Subject: Environment Agency Response to: BR/139/18/OUT

LPA ref: BR/139/18/OUT

Outline application with some matters reserved for the demolition of 1 no. Existing dwelling to form access for 6 no. Residential dwellings

Rear of 94-100 Hook Lane, Bognor Regis, PO22 8AT

FLOOD COMPENSATION AREA

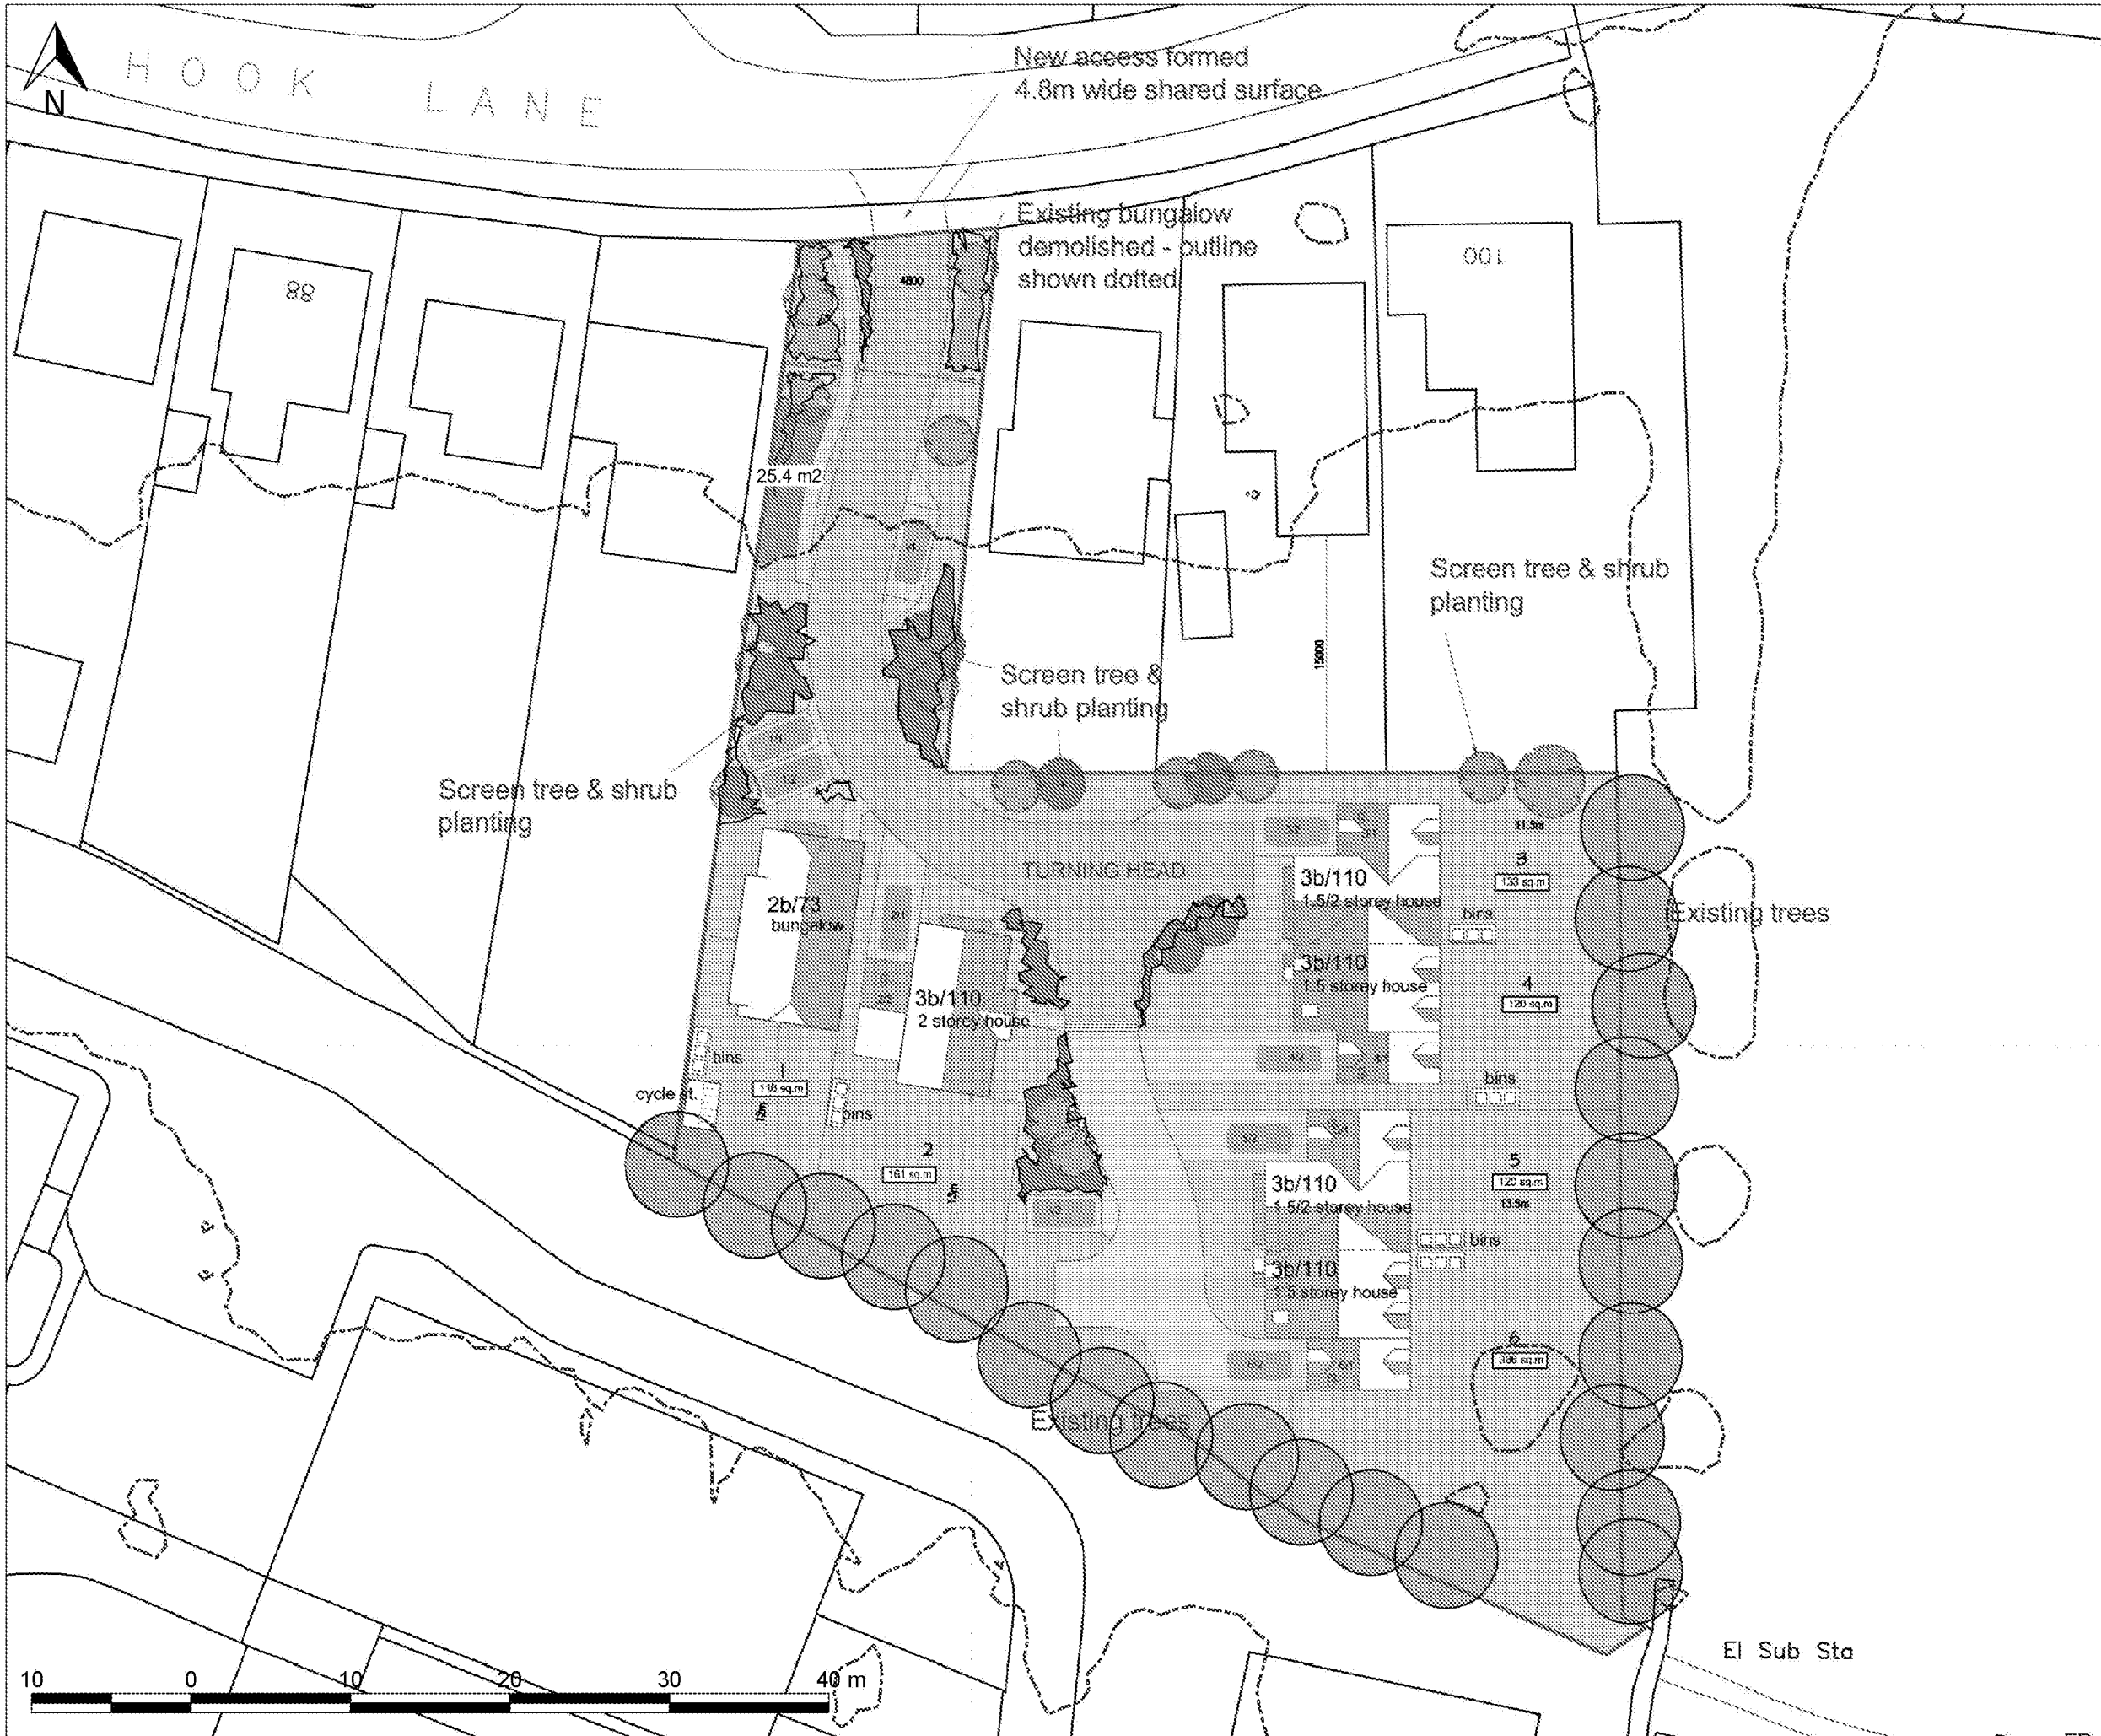
- More information about the proposed flood compensation is needed. Basic requirements for compensatory floodplain storage are as follows:
- A volume of floodplain equal to or larger than that lost to the proposed development must be created

- The volume must apply at all levels between the lowest point on the site and the design flood level. Normally this is calculated by comparing volumes taken by the development and the volume offered by the compensatory storage for a number of horizontal 'slices' through the range defined above

- The thickness of a vertical slice should typically be 0.2 metres. In the case of large flat sites or very steep sites this may be varied, for example for flat sites to 0.1 or even 0.05 metres. The slice thickness should be set to provide between ten and fifteen slices for such unusual sites.

- Due to the lack of information, it is not clear if it is proposed to use stilts or voids. This is not floodplain compensation, but rather mitigation of risk by design. The use of stilts reduces the impact on the development but does not guarantee that the floodplain will be retained in the same way as a compensation scheme (which is a form of risk substitution).

You can overcome our objection by submitting an FRA which covers the deficiencies highlighted above and demonstrates that the development will not increase risk elsewhere and where possible reduces flood risk overall. If this cannot be achieved we are likely to maintain our objection to the application. Production of an FRA will not in itself result in the removal of an objection.
